Application H16-0469-18
Location THE FITNESS COMPANY 38 SPRING GARDENS SPALDING PE11 2XL
Proposal Change of use of the existing building from use class D2 to use class C3, to include one 1-Bedroom apartment and eight 2-Bedroom apartments, proposed new four storey apartment building including twelve 1-Bedroom apartments, and associated external works and infrastructure.

Name Spalding & District Civic Society
Address Mr Robert West 94 Spalding Common Spalding PE11 3AU

Date Submitted 25-08-18
For/Against Objections

Drawing Title:
**Proposed New Apartments
Roof Plan & Elevations**

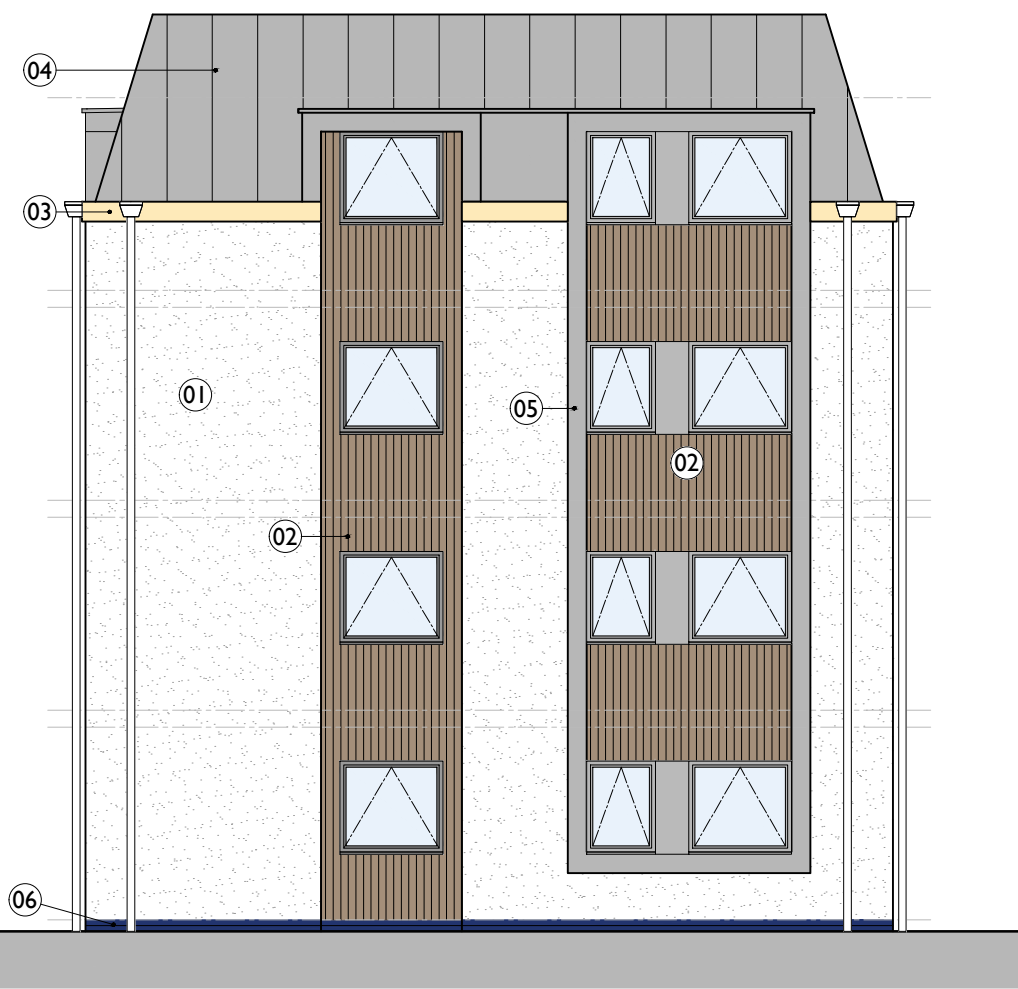
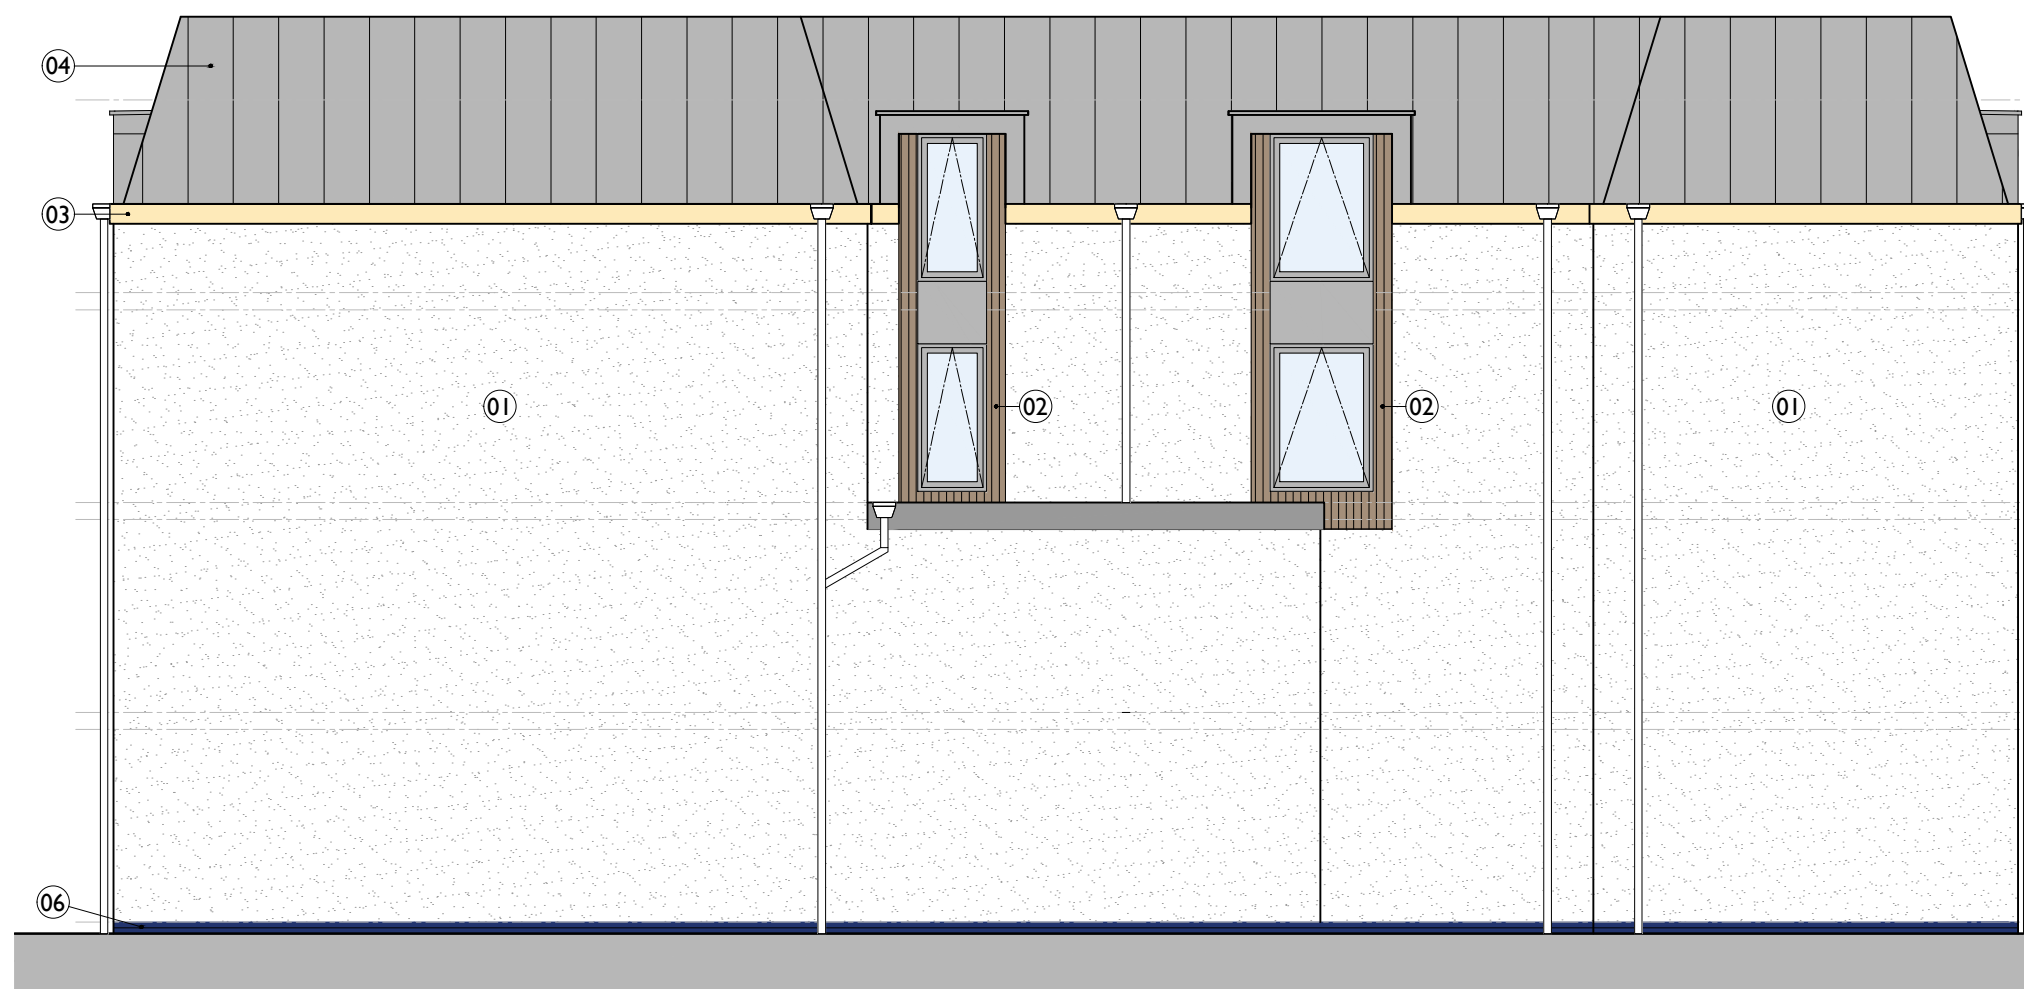
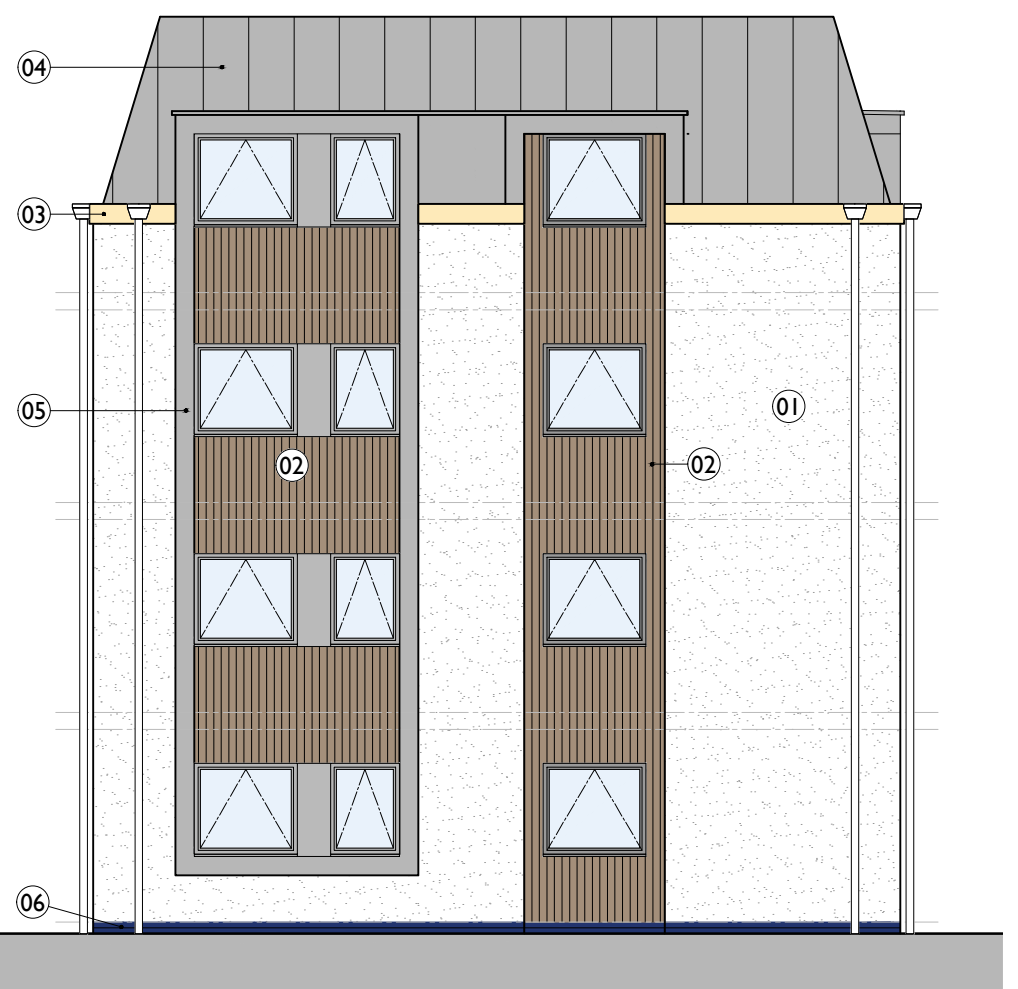
We have no problem with the conversion of the existing building into apartments. However, the proposed new block is far too big, blocking out views of the Sessions House, and presenting an almost blank wall to face the sorting office, which we expect and hope will be eventually demolished and replaced with residential or office buildings. This monolithic elevation will tie the hands of the future developer of the sorting office site. It is imperative that both sites be developed as an integrated whole, so that this important site in the Conservation Area will be able to present a unified face.
